From: [Holly Duncan](#)
To: [Jeff Watson](#)
Subject: RE: BL-10-00023 Haberman
Date: Tuesday, June 22, 2010 3:03:53 PM

[BL-10-00023 Haberman](#)

**STEWART PROPERTY**

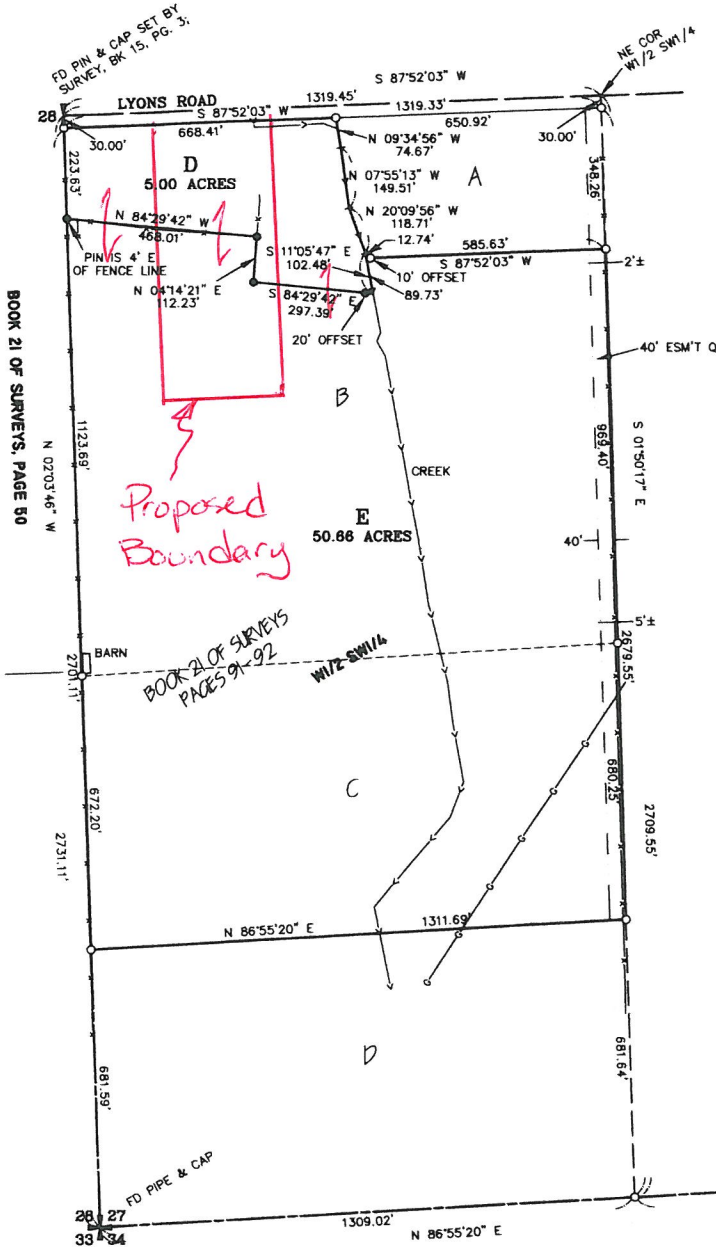
I am curious where the drainfield and well is on this one too.
